DRB Application No.: 05DRB-01295 (P&F)

Project Name: ALTURA ADDITION

DEVELOPMENT REVIEW BOARD – SPEED MEMO

Subject: Requested action – comment administrative approval, Plat of Tract A-1 and A-2,
Block 10, Altura Addition (Lacy)

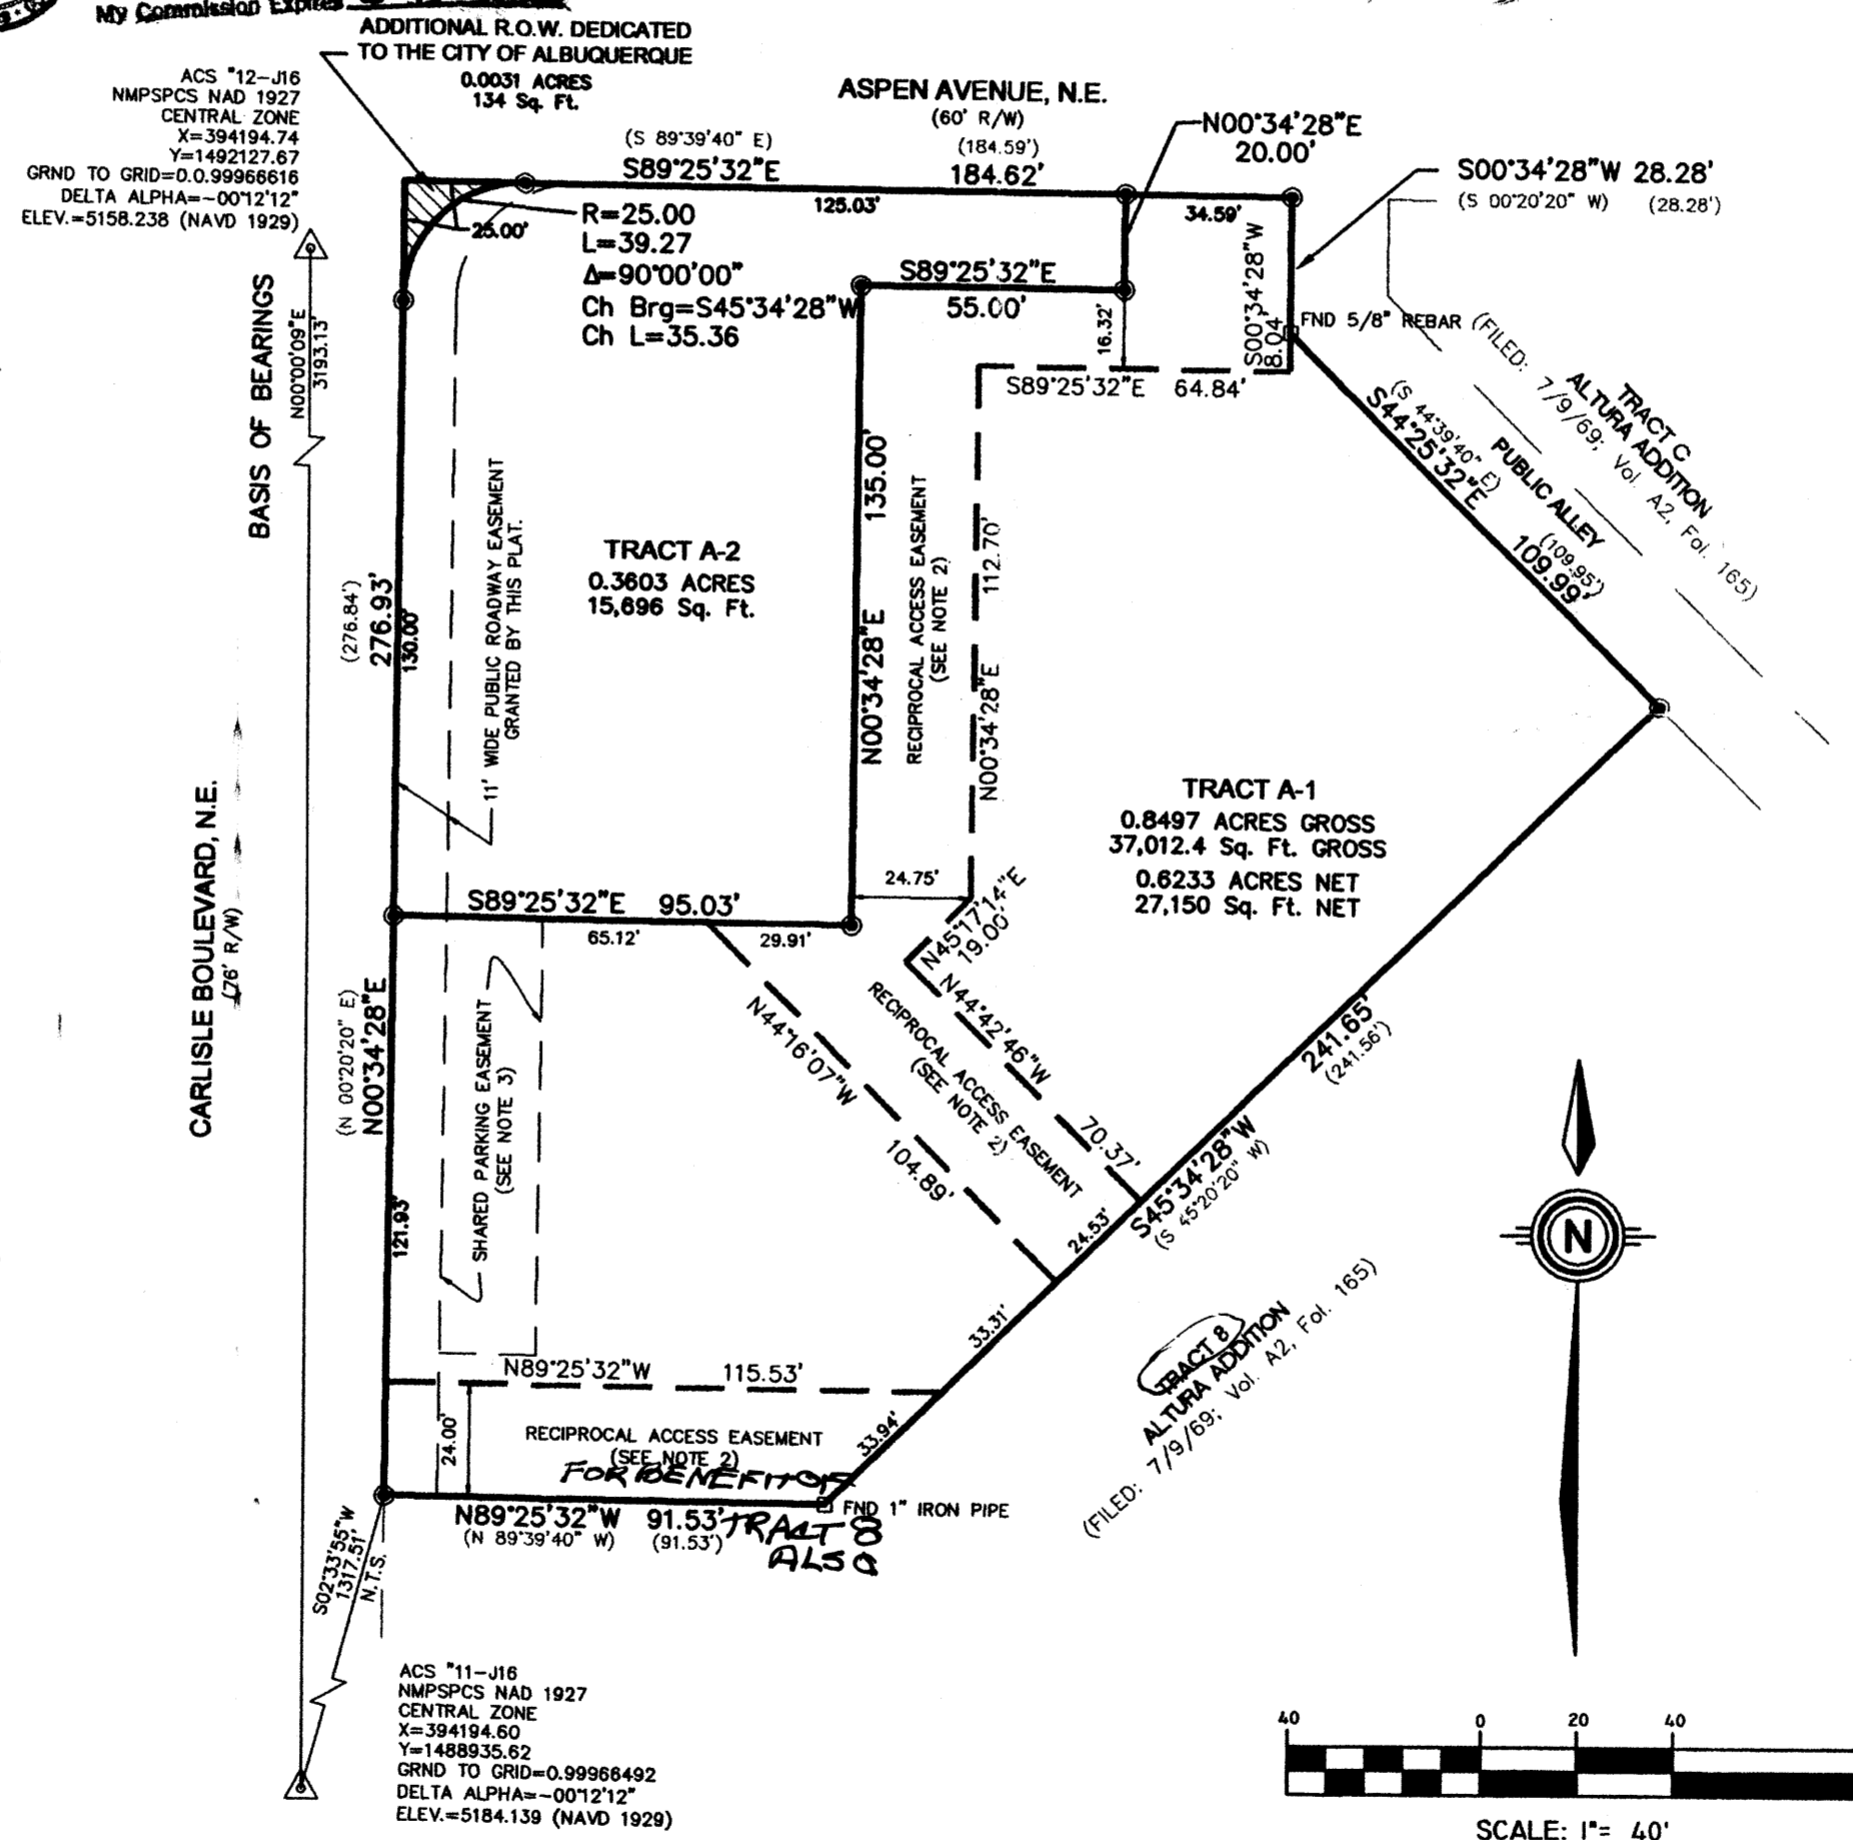
Minor plat comments.

TRACTS A-1 AND A-2

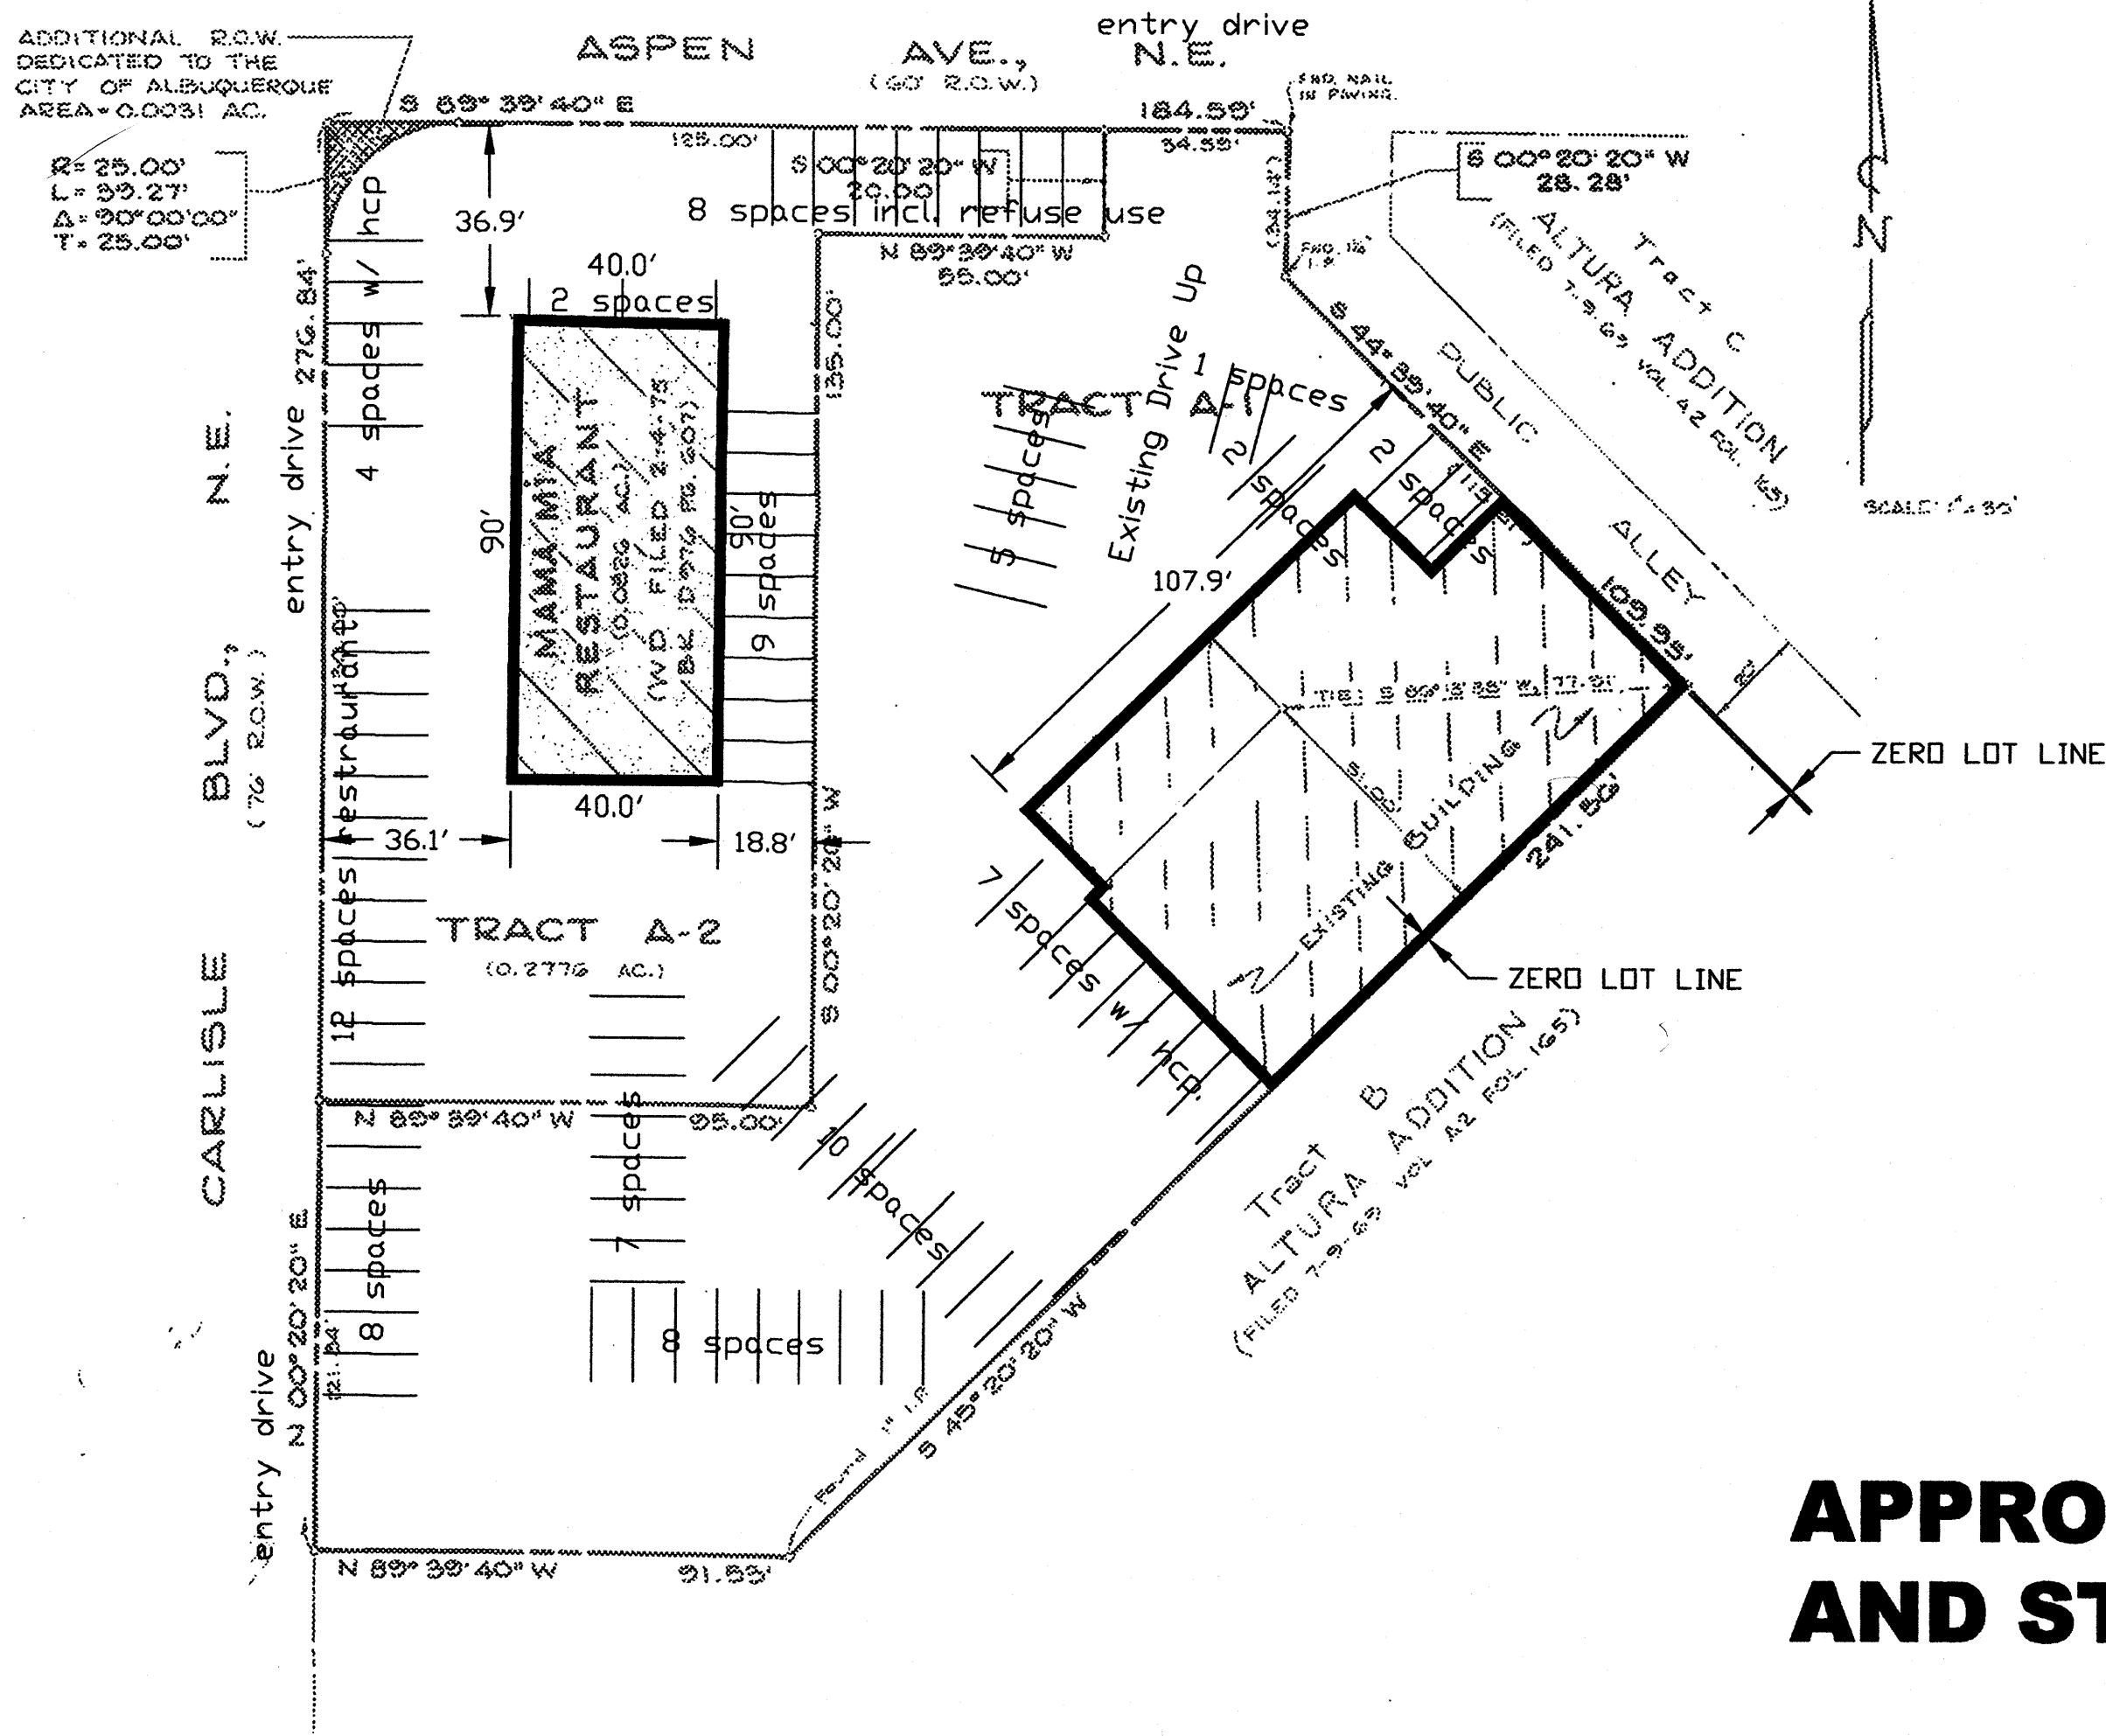
Crosslot drainage easements may be required – see drainage file J17-D22.

*Existing platting + ownership very unusual.
Appears property sold w/out properly recorded plat.
Required parking must be on-site. What happens if parking easement on adjacent property is cancelled by owner of that property?*

NOTE 2 REVISION: 2. WITH THE APPROVAL AND RECORDATION OF THIS PLAT, THERE IS HEREBY GRANTED BY LACY INVESTMENTS THE RECIPROCAL ACCESS EASEMENTS ON AND OVER TRACT A-1 AS SHOWN HEREON. SAID EASEMENTS ARE TO BENEFIT TRACT A-2 HEREON AND TRACT 8, ALTURA ADDITION FOR DRIVE AISLE INGRESS AND EGRESS AND ARE TO REMAIN UNOBSTRUCTED.

NEW NOTE 3: 3. THE UNDERSIGNED FOR TRACT A-2, AS SHOWN HEREON IS REQUIRED TO MAINTAIN AT LEAST FORTY (40) PARKING SPACES AS REQUIRED BY THE CITY OF ALBUQUERQUE, NEW MEXICO, FOR THE RESTAURANT USE ON THAT LOT AS CURRENTLY CONFIGURED ON THE DATE OF THIS PLAT. ANY CHANGES OR REVISIONS TO THE USE OR SIZE OF THE STRUCTURE, IF ANY, WILL REQUIRE RECALCULATION AND CONFIGURATION OF THE PARKING REQUIREMENTS AS PROSCRIBED IN THE CITY OF ALBUQUERQUE ZONING CODE.
